Item No. **Report of the Head of Planning, Building Control, Sport & Green Spaces**

Address FLAT 1, 16 DUNEDIN WAY HAYES

Development: Single storey rear extension to existing ground floor flat

LBH Ref Nos: **32525/APP/2015/3117**

SINGLE STOREY EXTENSION	AUGUST 2015	
JAMES RUSH ASSOCIATES LTD	DRAWING No. 1471.2

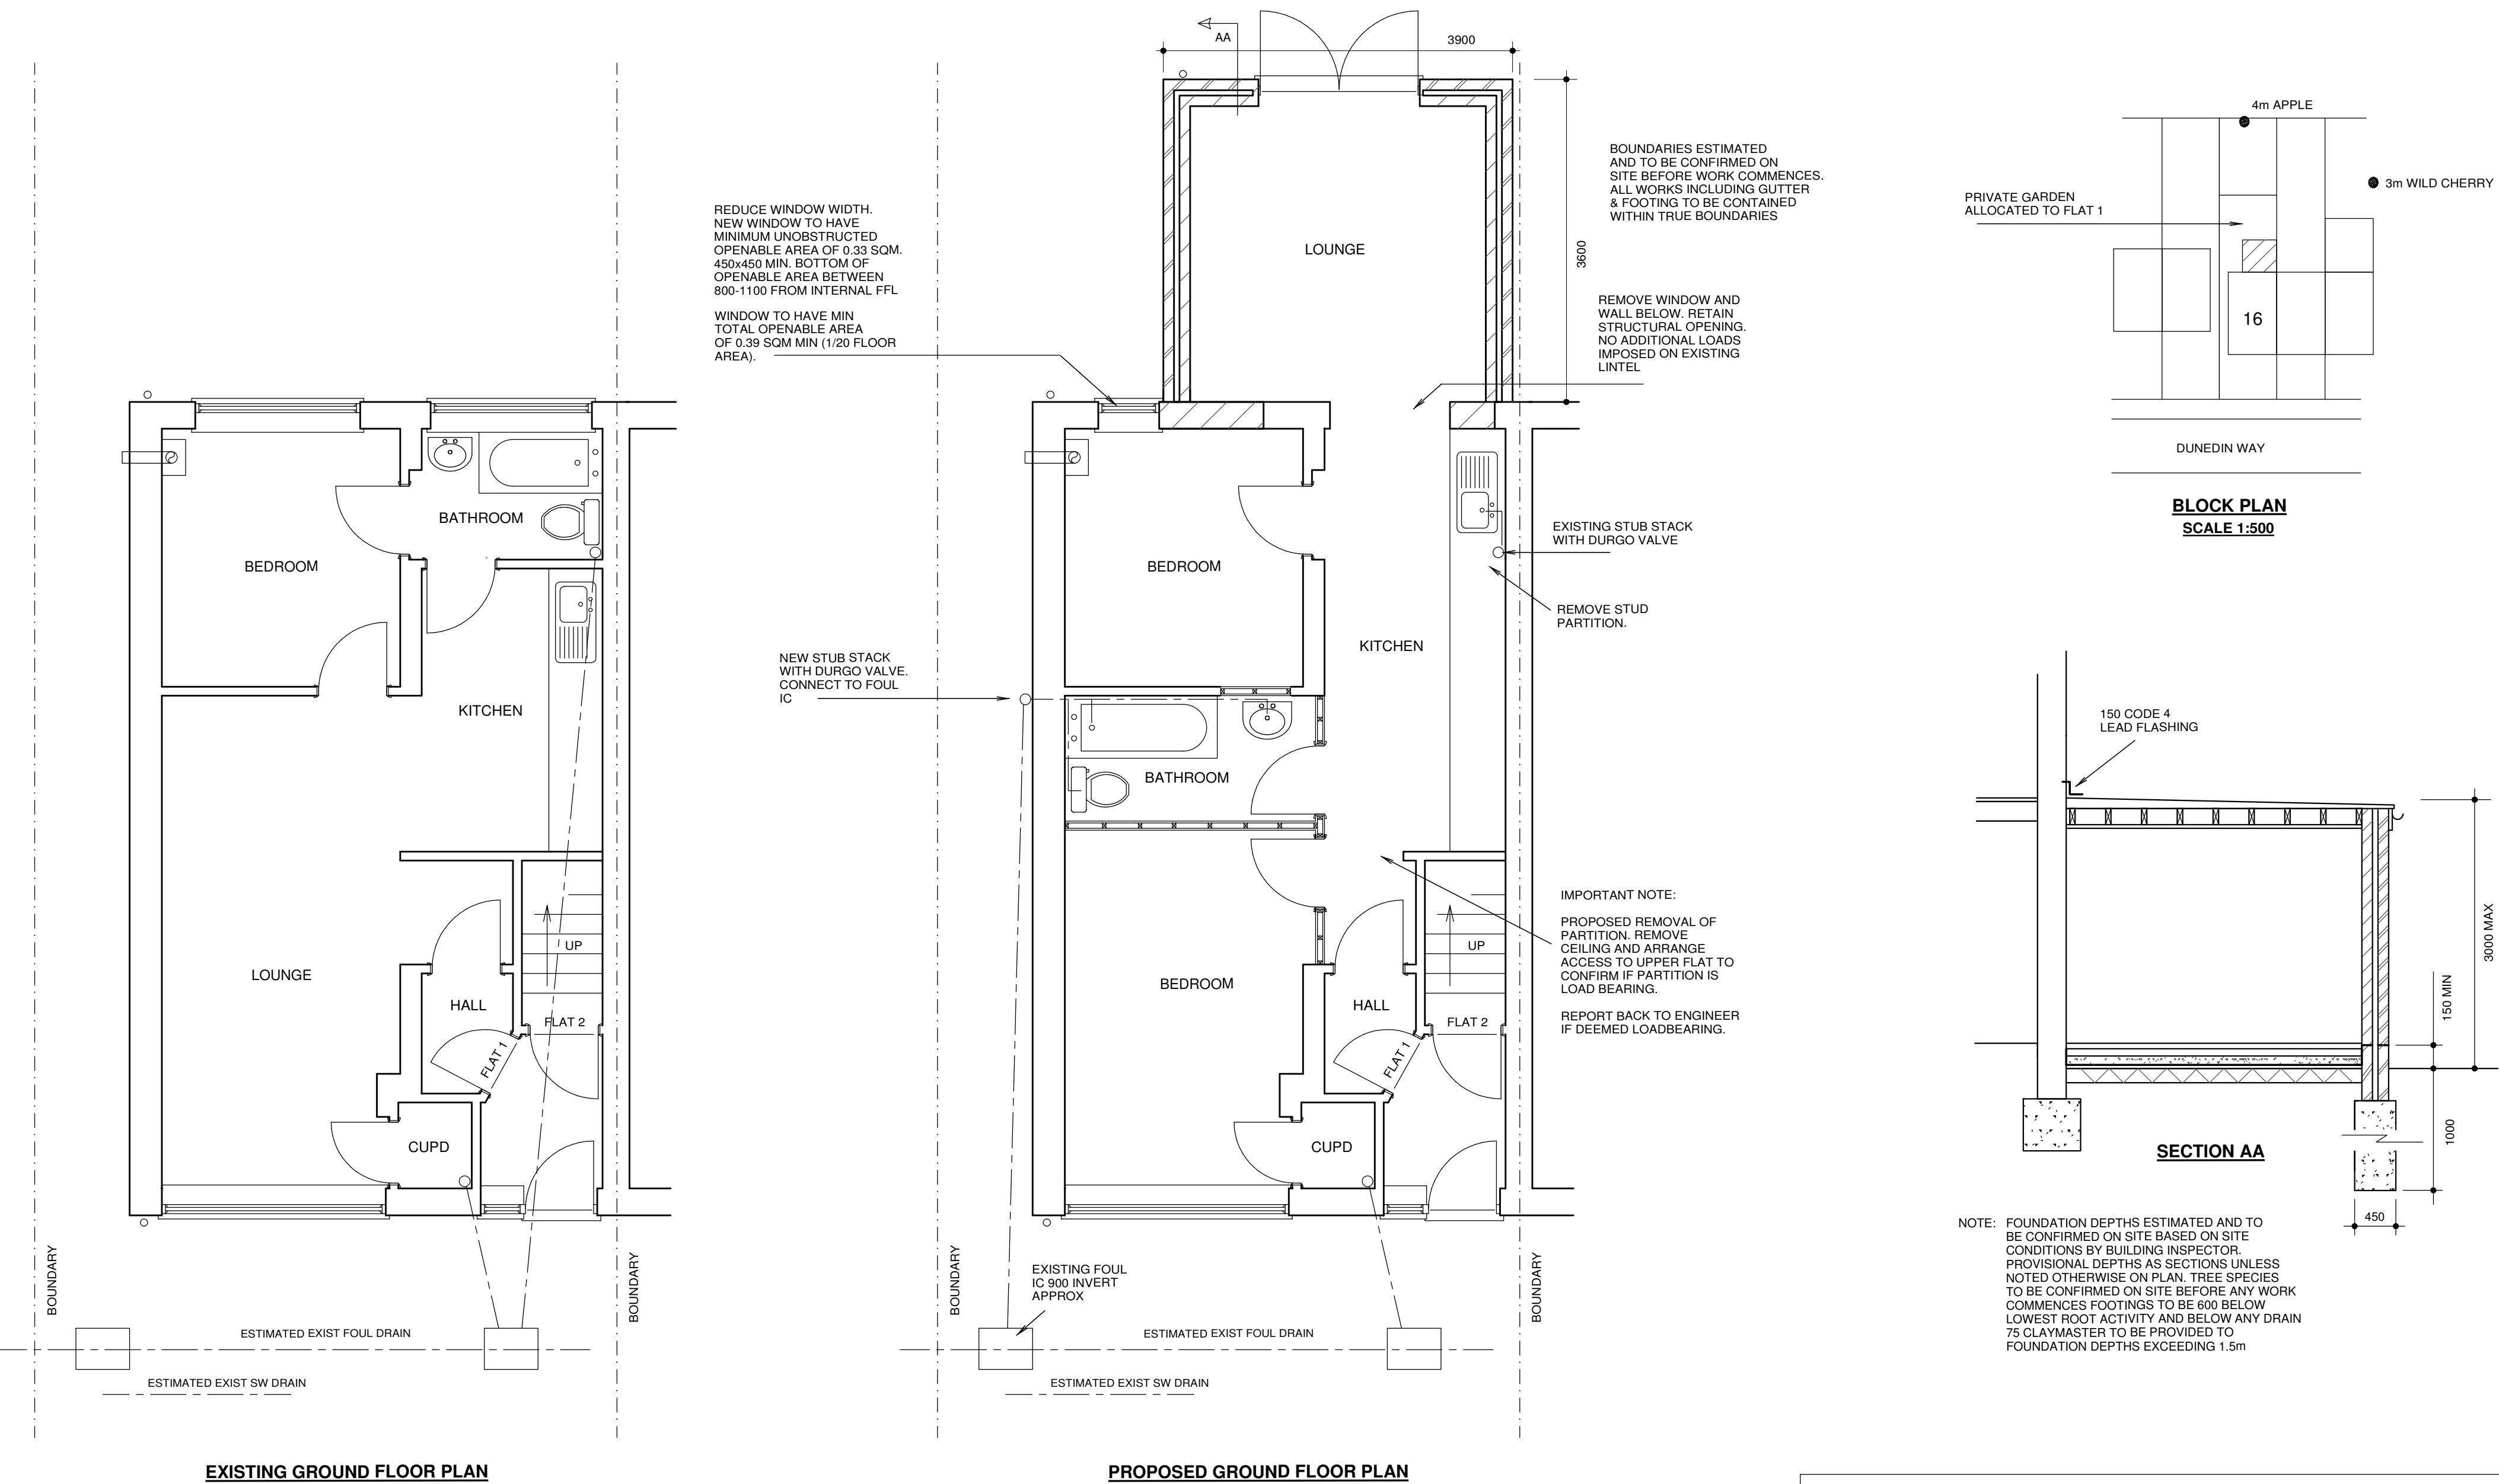
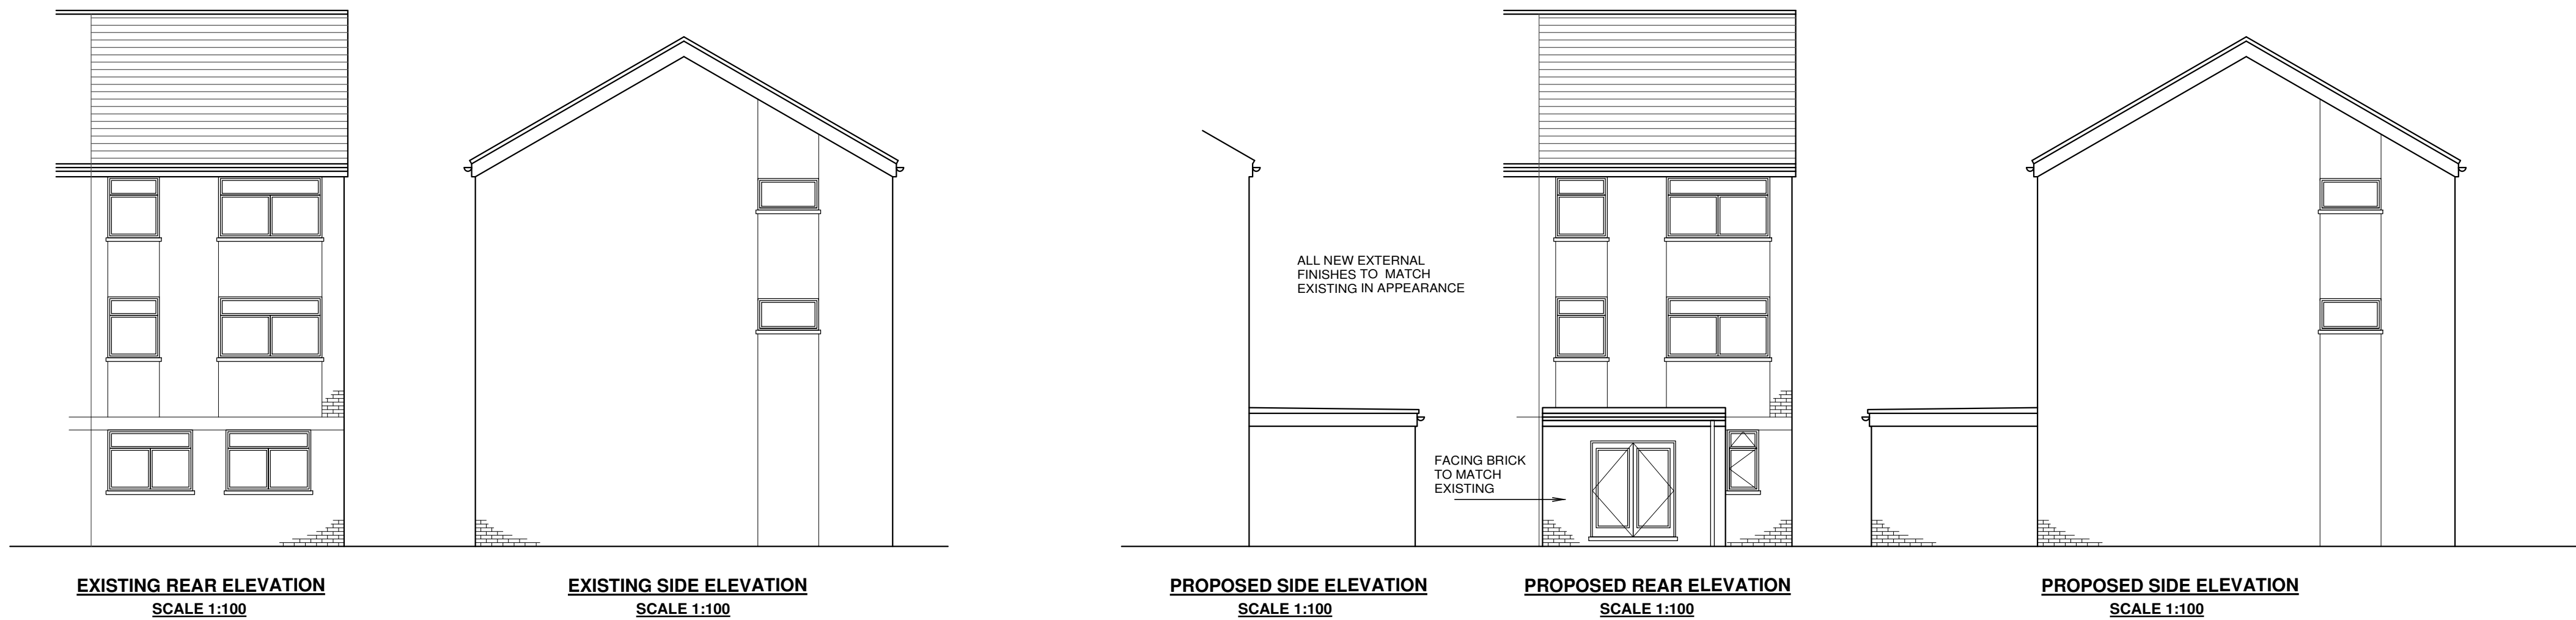
The application seeks planning permission for the erection of a single storey rear extension to the existing ground floor flat to provide a new lounge. The extension would project 3.6m in depth by 3.9m in width and would be set along the boundary with adjoining number 14 Dunedin Way. The extension would be finished with a flat roof measuring 2.95m in height. The extension would allow for an internal re-arrangement of accommodation to provide a second bedroom.

Compliance with the height and depth restrictions as recommended above means that the extension would not harm the amenity of nearby residents through loss of daylight. The proposed development would not have any windows on the side elevations which would prevent overlooking and loss of privacy to adjoining occupiers. Therefore, it is considered that the proposed development would not constitute an un-neighbourly form of development in compliance with Policies BE19, BE20 and BE21 of the Hillingdon Local Plan: Part Two - Saved UDP Policies (November 2012).

Both in terms of its height and depth, the proposal would accord with the above criteria and therefore would appear subordinate to the main property. Moreover, the extension would not be visible from the street scene and would be constructed using matching materials. There are a number of larger extensions in the nearby vicinity. As a result it is considered that it would not have a negative impact upon the visual amenity of the site or the surrounding area in compliance with Policy BE1 of the Hillingdon Local Plan: Part

In terms of the garden area at least 40m² of rear private garden should be retained to provide adequate amenity space for a two bedroom flat. The resultant amenity space would be 43m² which would be in excess of the paragraph 3.13 HDAS requirement. The proposal would be in accordance with Policy BE23 of the Hillingdon Local Plan Part 2.
